**Block 4B Central Park Adaptive Reuse (SSD-9374 and MP 06\_0171 MOD 16)  
Request for Additional Information**

## Attachment 1

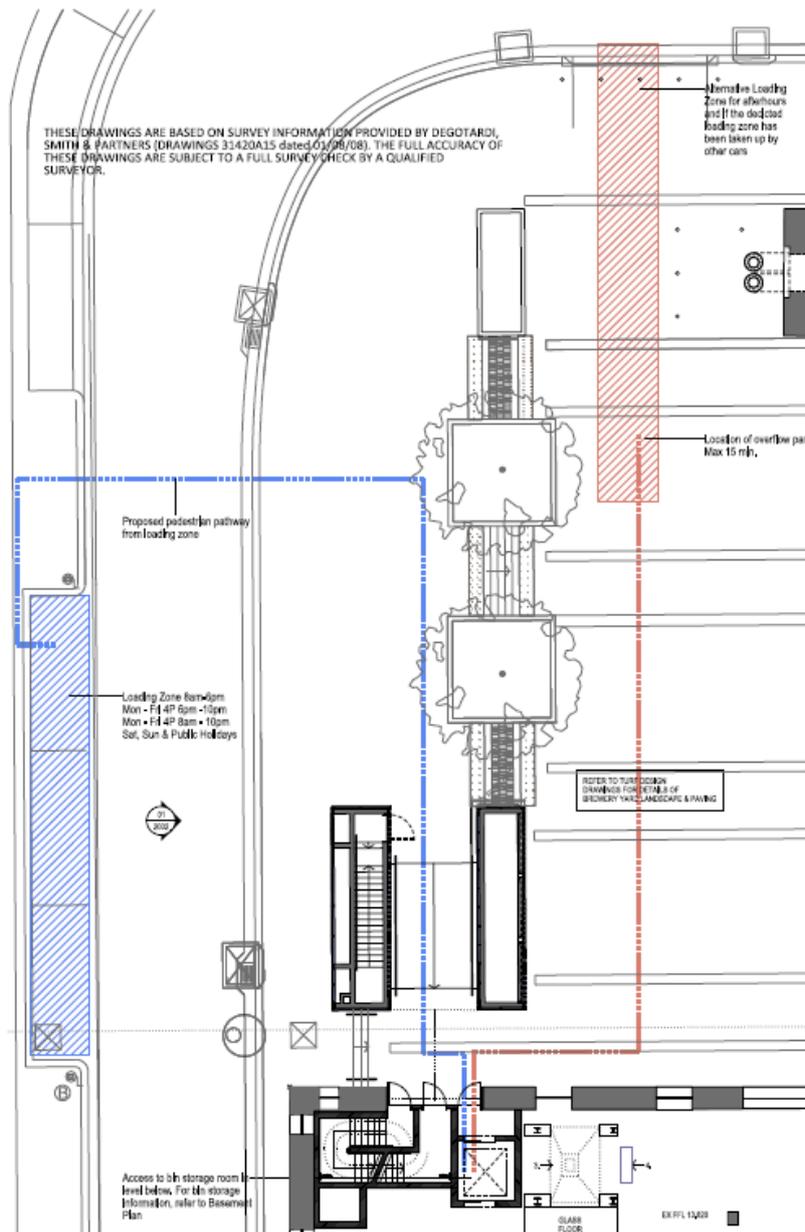
The Department notes Council continues to have concerns about heritage impacts, servicing and waste. The Department encourages further consideration of these elements, in consultation with Council, prior to the Department finalising its assessment.

- an update on the status of the referral to Council's Traffic Committee to change existing parking spaces on Central Avenue to a loading zone
- investigate option 6, as outlined in the letter from GTA submitted in January 2020, to use existing loading docks across the Central Park precinct where no other options are feasible
- identify the waste collection point on plan, including path of access (user and vehicles) from the collection point to the bin storage room.
